Ann Machado - Re: 4 Adams St., Peaks Island - permit #2014-02164

I have completed my initial zoning review.

ELEVATIONS

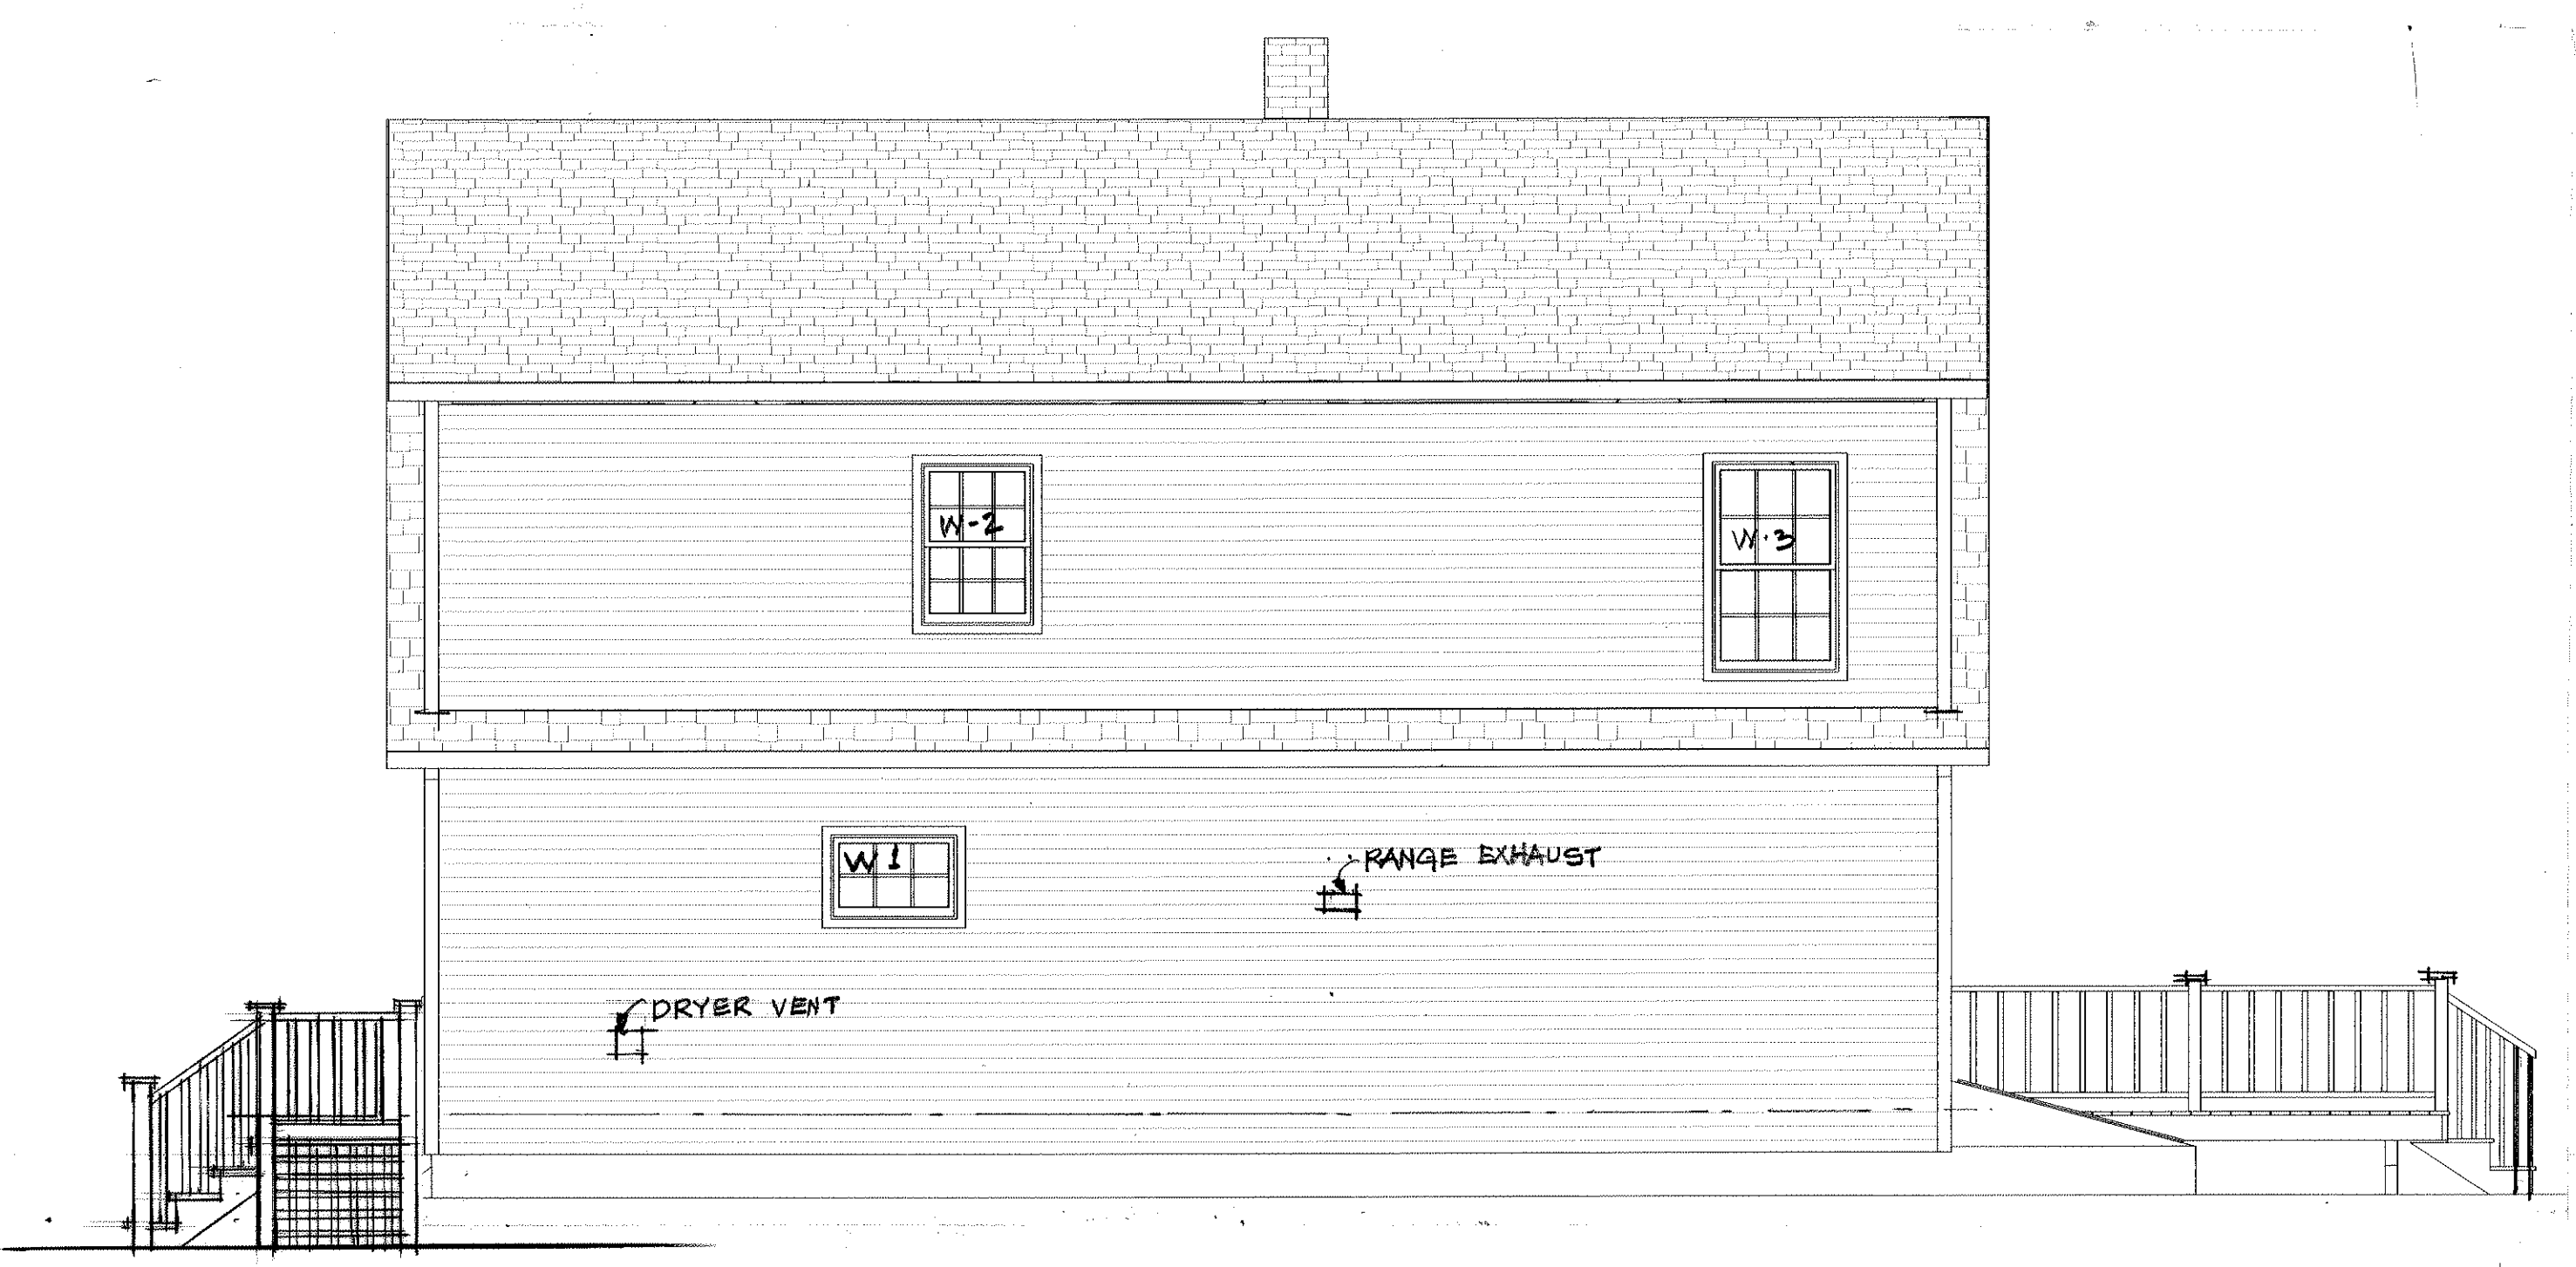
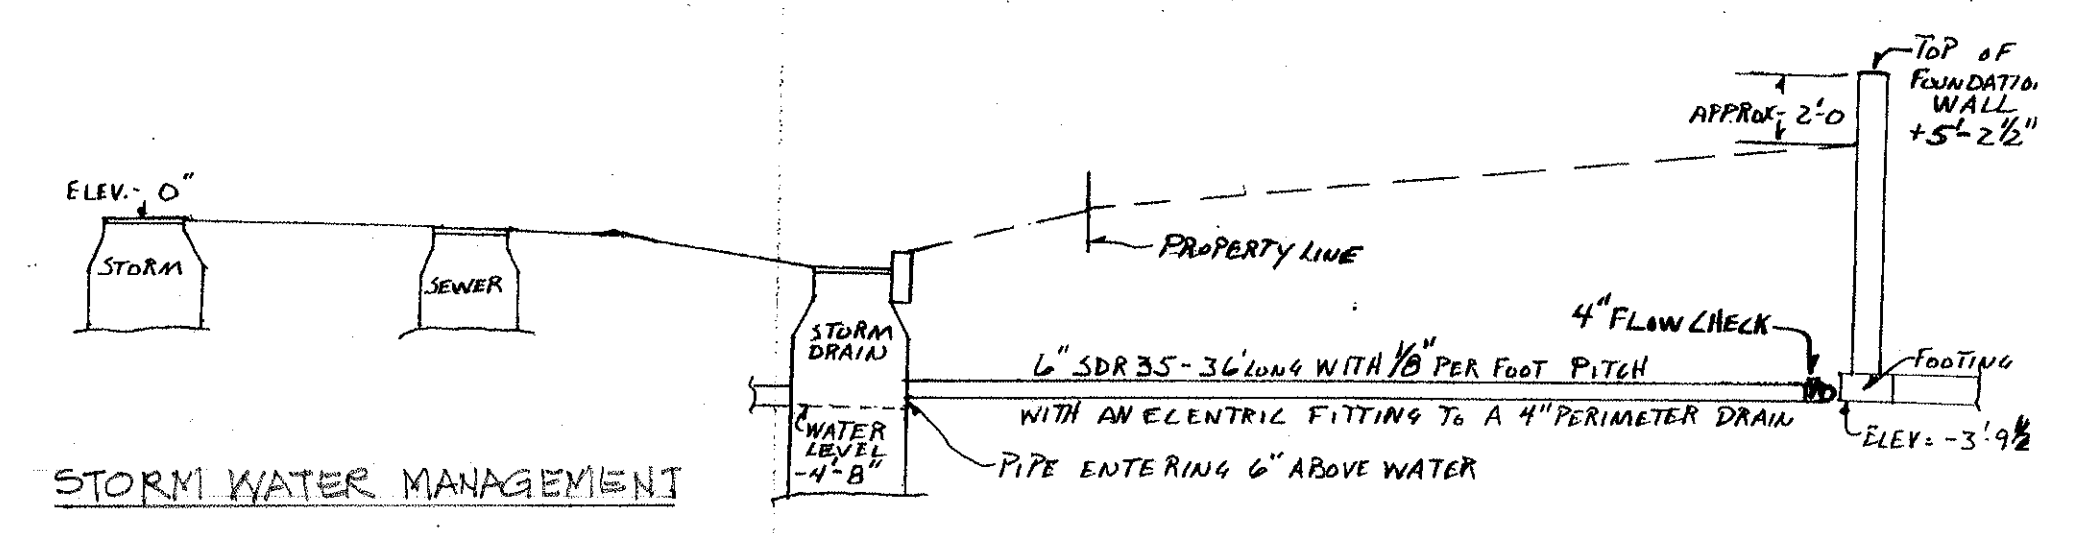
First of all, this permit does not fit the fast track application category. You checked New Sprinklered One & Two Family Homes as a category. You can only use this if all the plans bear the seal of a licensed design professional. All the plans need bear the license; A1 Proposed Exterior Elevations and A2 Proposed floor Plans do not bear a seal. It will need to go through the regular review process.

As far as A1 goes, this was an oversight and the engineer is working to correct it for us. I will be resubmitting the exterior elevations page with his stamp on the front. I am hoping to hear back from him and resubmit it today.
